Your Ref: **32111000**
Our Ref: **G pre00220/2019**
(Please quote in all related correspondence)

06 July 2020

Re: Scoping Document for proposed replacement of 7 manned level crossings between Limerick Junction and Cork City on the Dublin-Cork Railway line.

Figure 16: Aerial view of site XC215 Shinanagh Ballynageragh, showing interpretation of geophysical survey

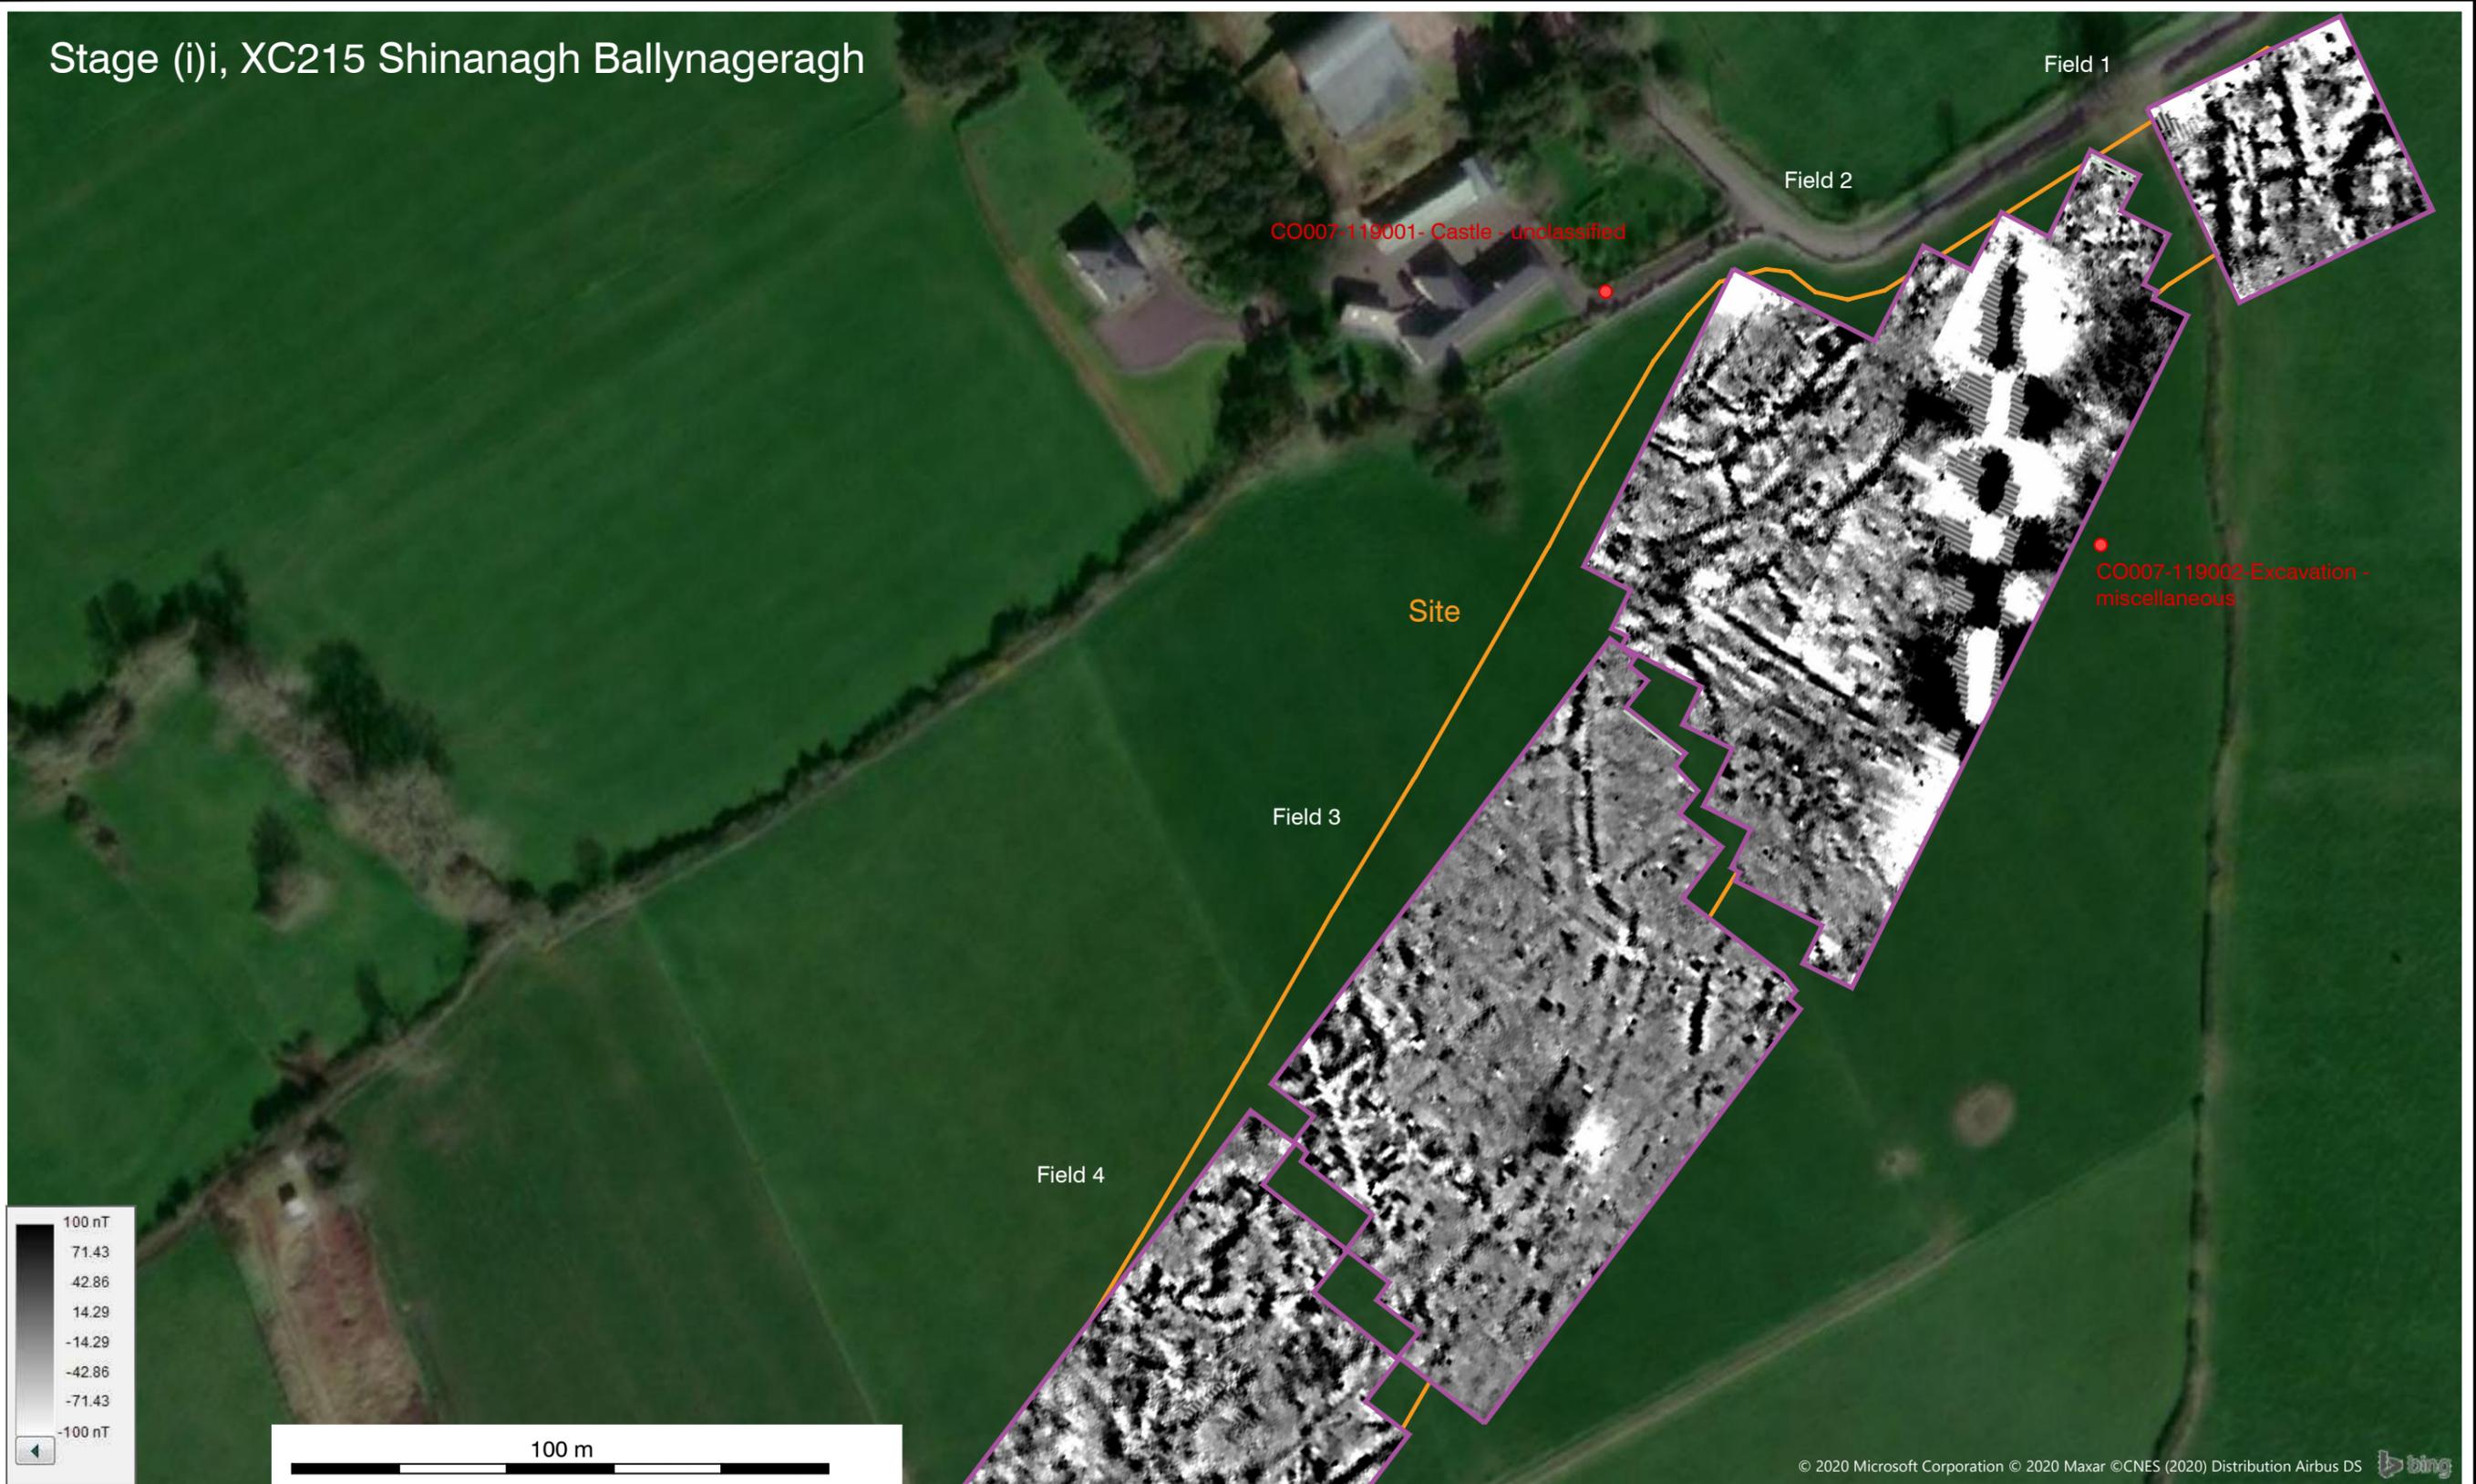
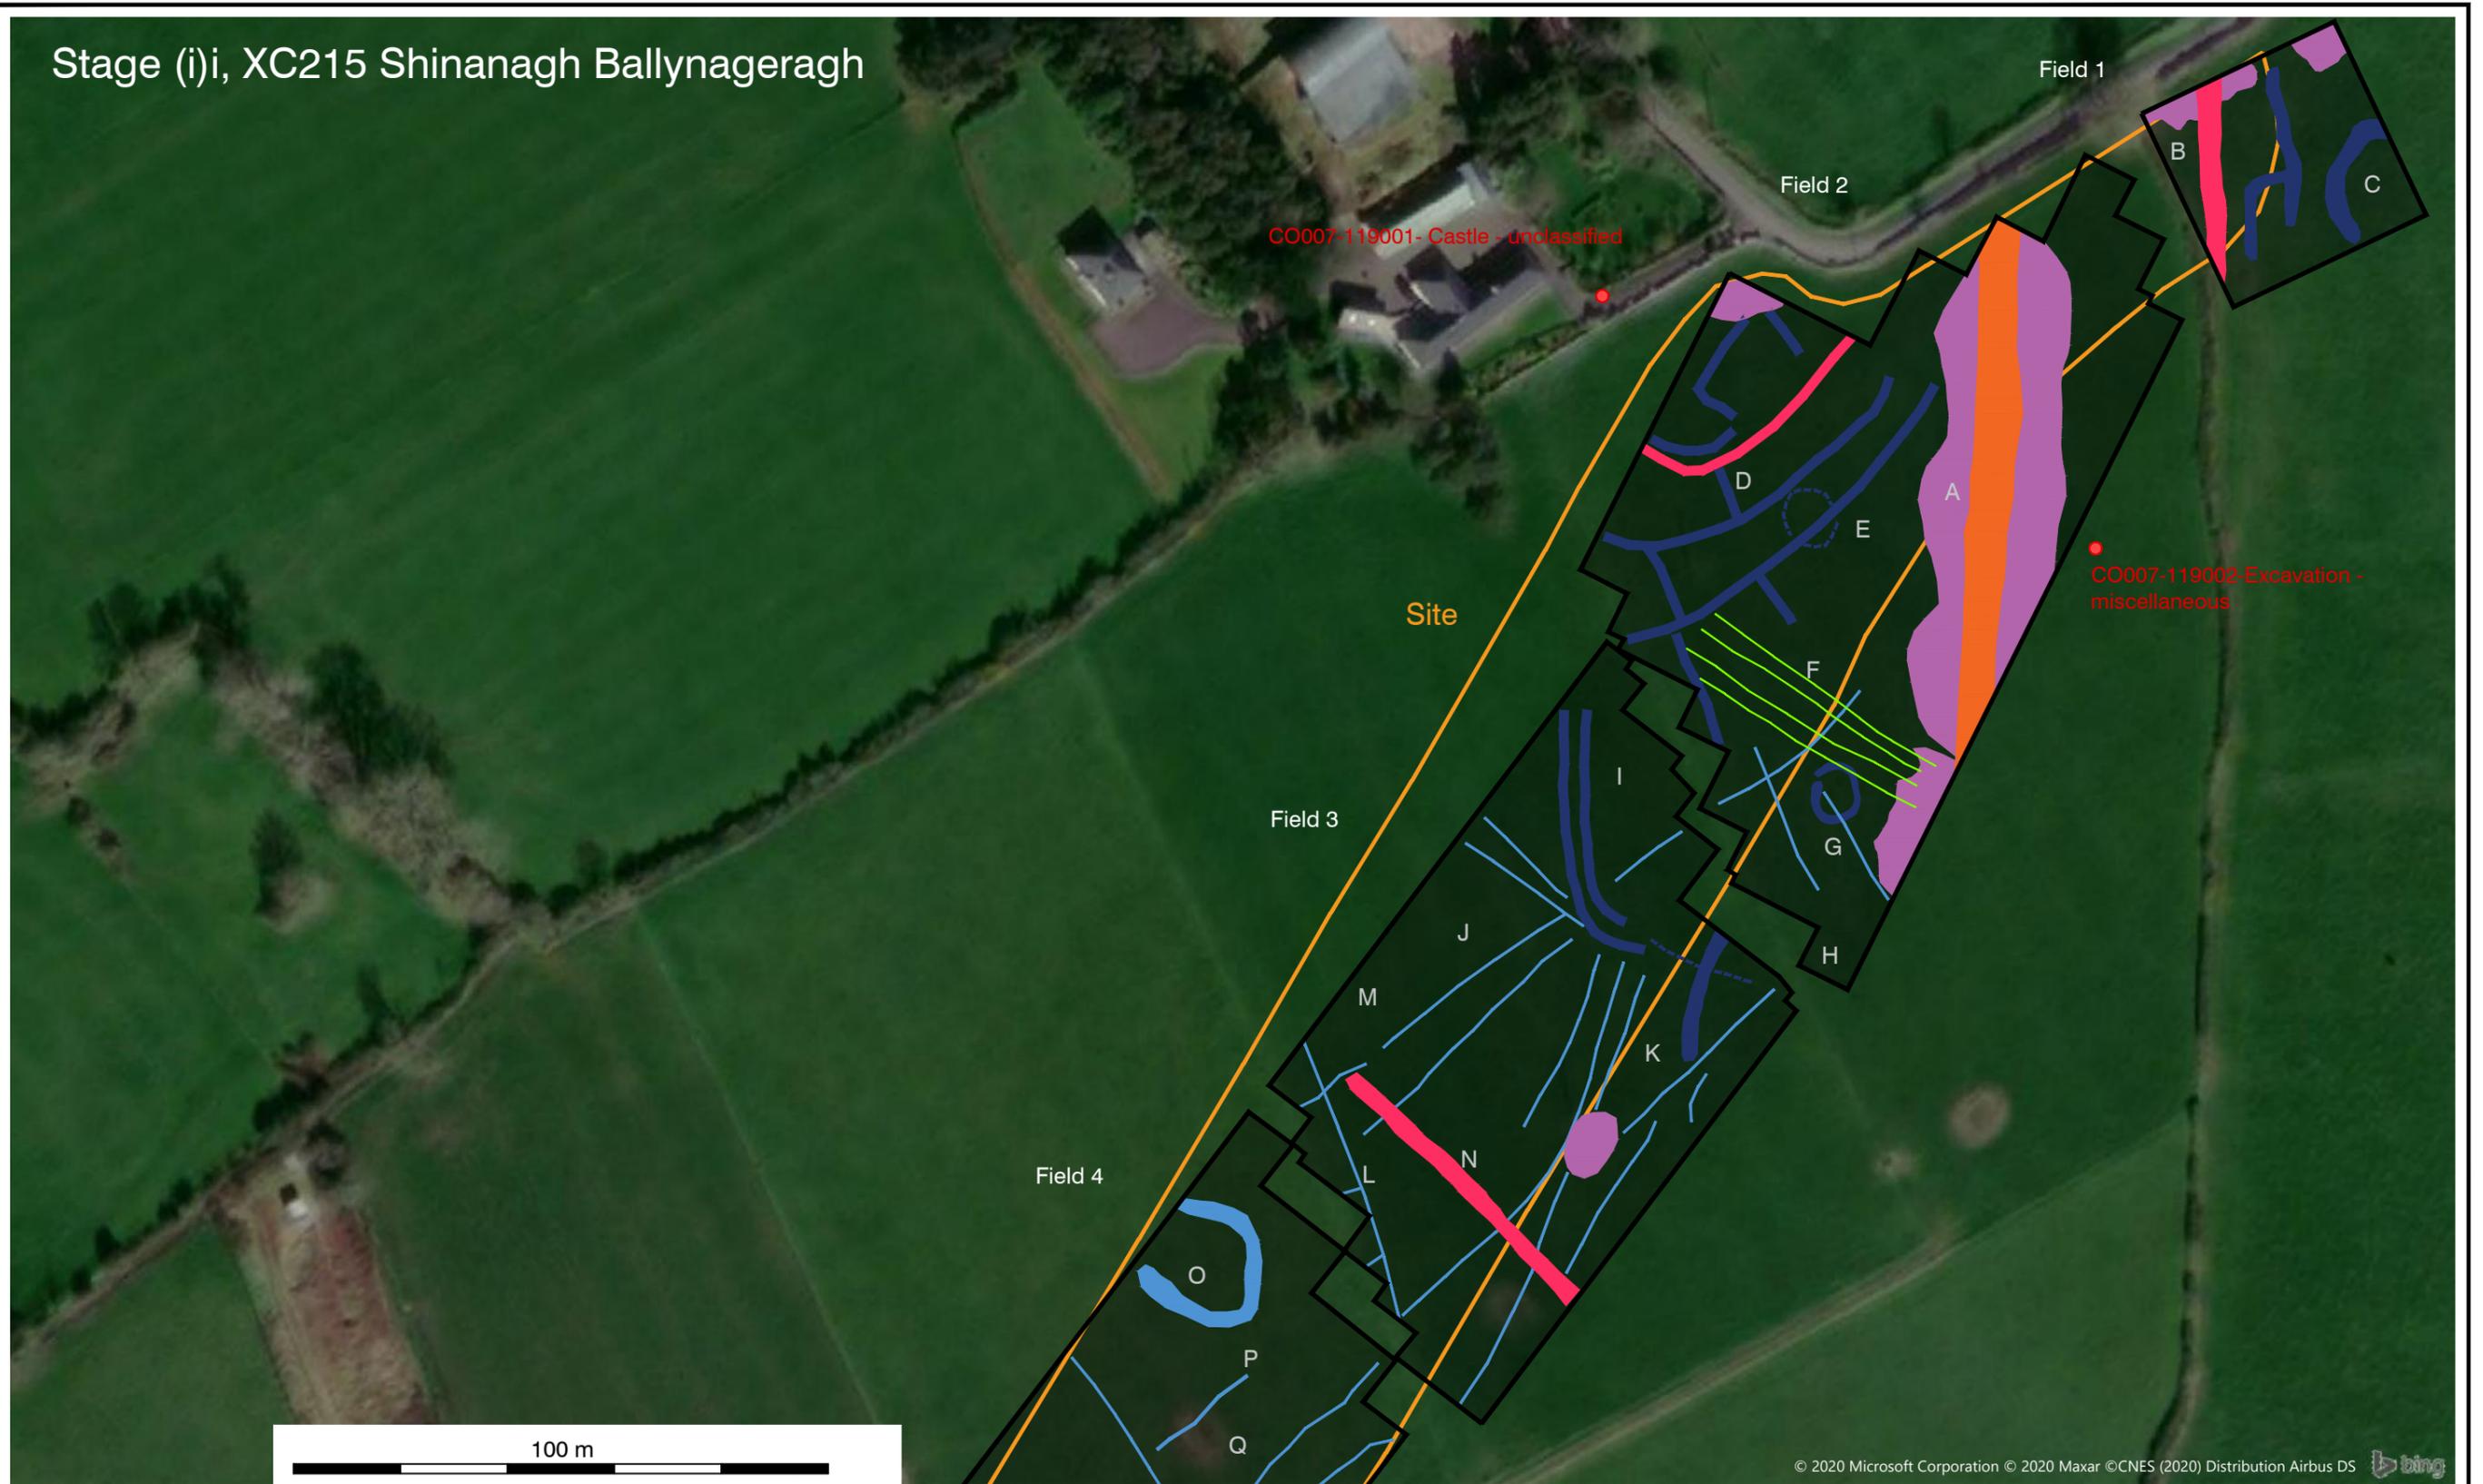
4. As the archaeological impacts in Shinanagh/Imprick have the potential to be direct and significant, geophysical survey is to be carried out in the vicinity of a route previously considered for selection to the west of RMP CO007-120 in Ballynageragh townland. The NMS (DCHG) notes that this route was previously discounted due to its' proximity to RMP CO007-119(001-) *Rathmore Castle* and CO007-119(002-) *Excavation (occupation site)*. However as the 'Ballynageragh Route' has not been fully archaeologically assessed, a geophysical survey needs to be carried out here in order to establish whether subsurface archaeological features/deposits survive. This may then be followed-up with a programme of archaeological test excavation. This mitigation strategy may then facilitate the selection of alternative route for the development should the impacts of the current proposal at Shinanagh/Imprick be deemed to be of a greater archaeological impact *viz a viz* the Ballynageragh route. Of particular concern are the internal features highlighted within the newly recorded enclosure. If testing reveals that this feature represents the remains of a souterrain, The Department would be concerned that this feature would collapse during construction works.
